From: Patz, Logan W.
To: ["doug@rba81.com"](mailto:doug@rba81.com); ["Rick@rba81.com"](mailto:Rick@rba81.com)
Cc: [Ortiz, Monica](#)
Subject: Xtreme Storage Tenant Improvement, 100 Trumbull Ave SE
Date: Friday, January 20, 2017 9:58:00 AM

There are four items that need to be addressed at the site listed above before we can issue a CO.

DATE
5/20/2016
SHEET NUMBER
TCL-1

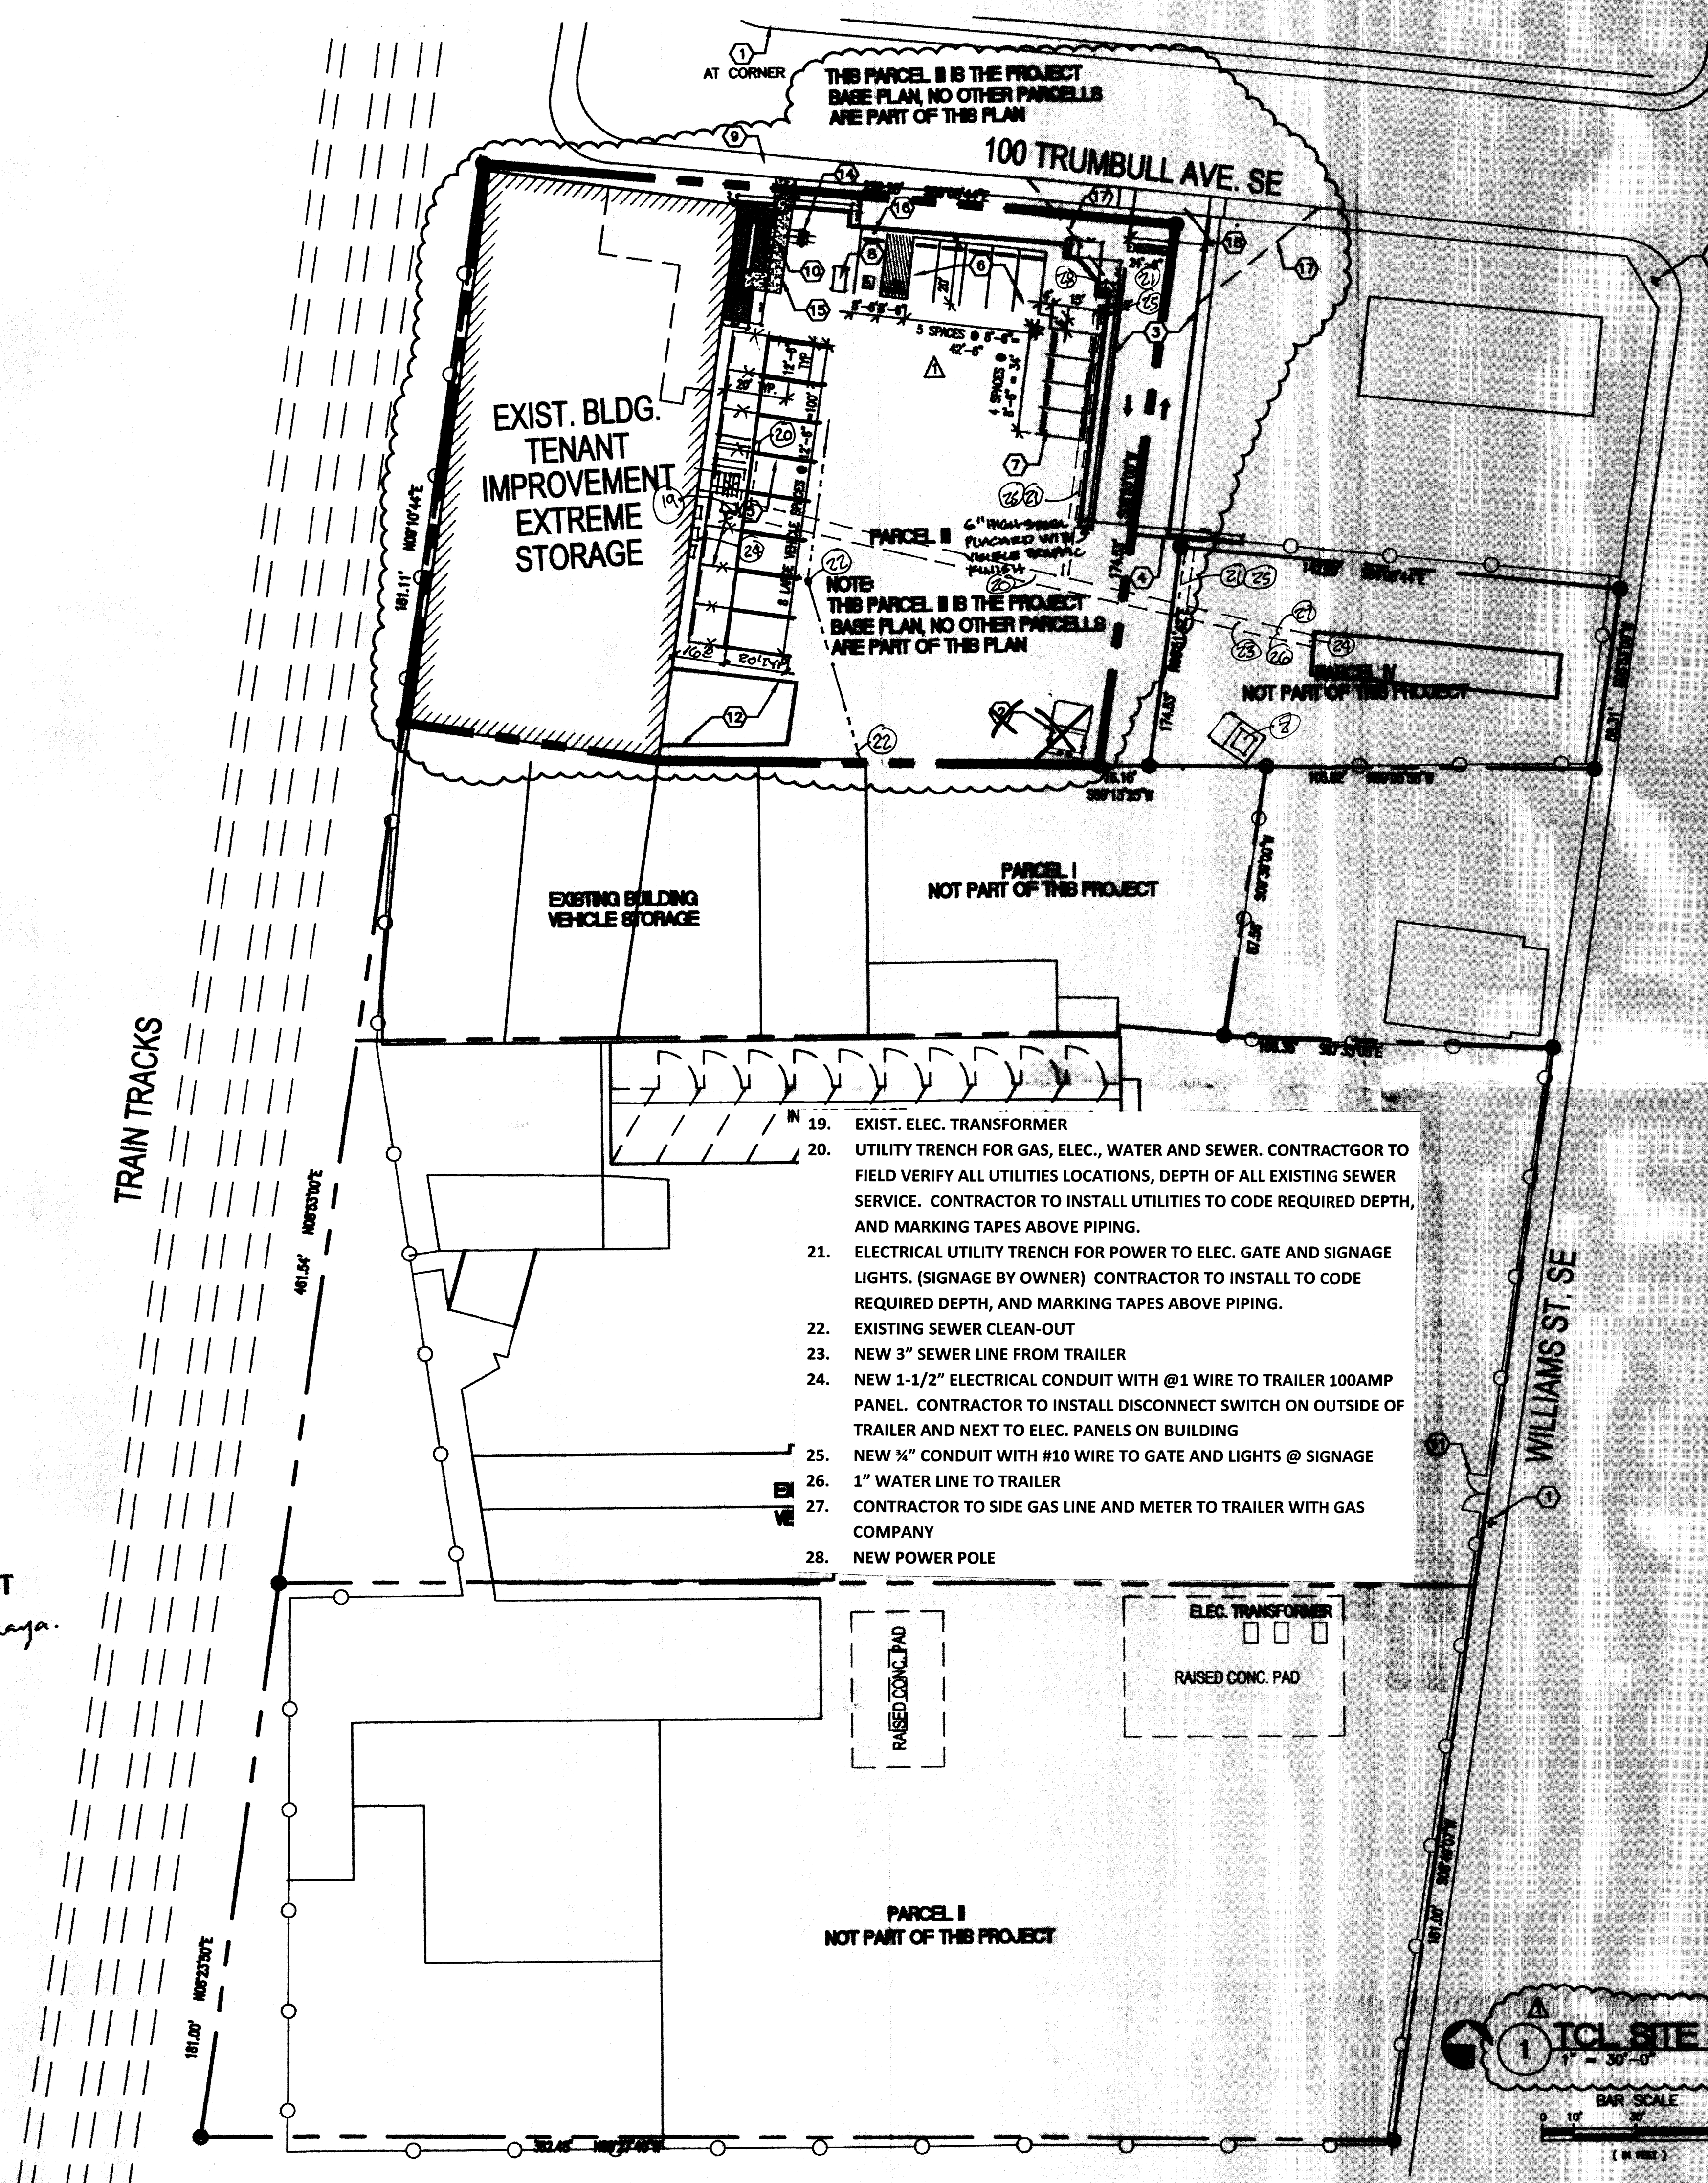
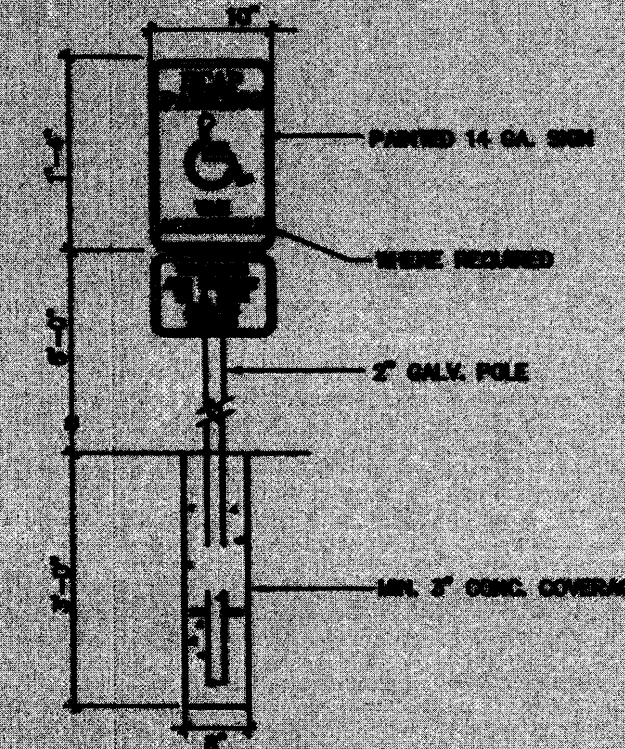
1. The Handicap Ramp going to the front needs to meet ADA requirements. The concrete before the ramp appears to be out of compliance.
2. The ADA accessible parking sign must have the required language per (66-7-352.4C NMSA 1978) **"Violators Are Subject to a Fine and/or Towing."**
3. The motor cycle space needs to be identified.
4. Please remove all construction debris from the construction site. (The old stairs should be removed)
